WINSOME FILING NO. 3 CULVERT CONSTRUCTION DOCUMENTS

WINSOME FILING NO. 3
EL PASO COUNTY, COLORADO
CONSTRUCTION DOCUMENTS
COVER SHEET

Culvert CDs_v2 redlines.pdf Markup Summary

75° SKEW-CULVERT 1

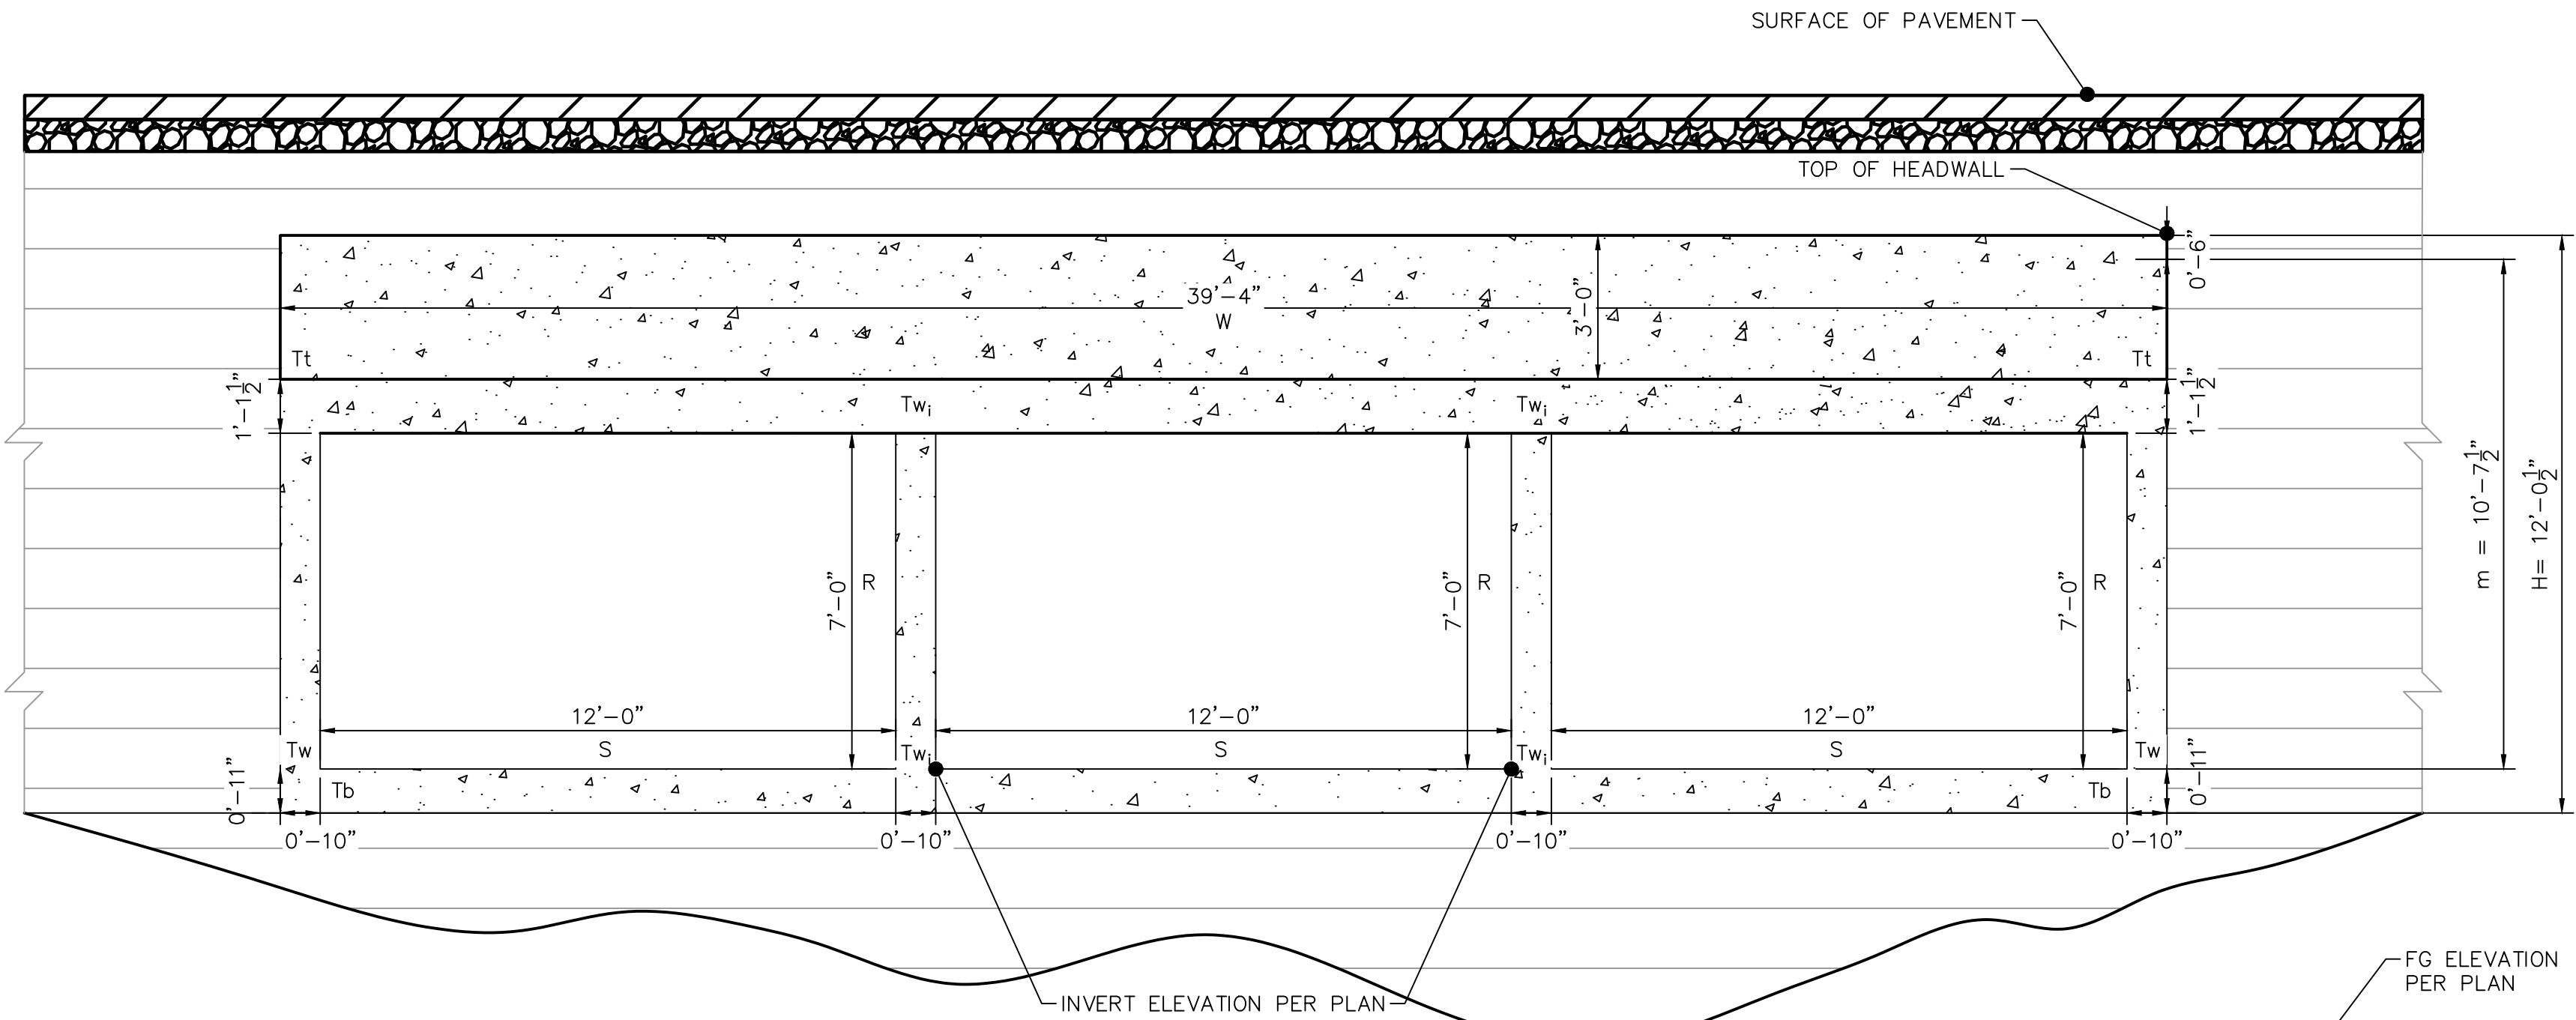
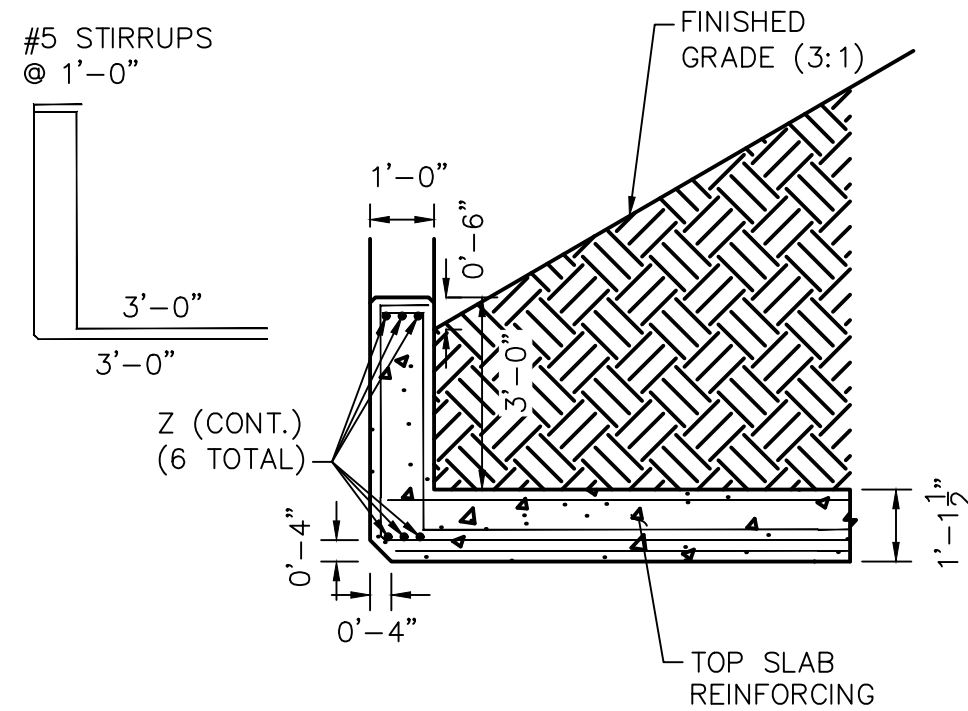
Is this applicable and has this been provided?

Include Figure on plans

SINCE THE STRUCTURAL DESIGN IS PER STANDARD DETAIL, THE RATING IS THE LAST 4 COLUMNS
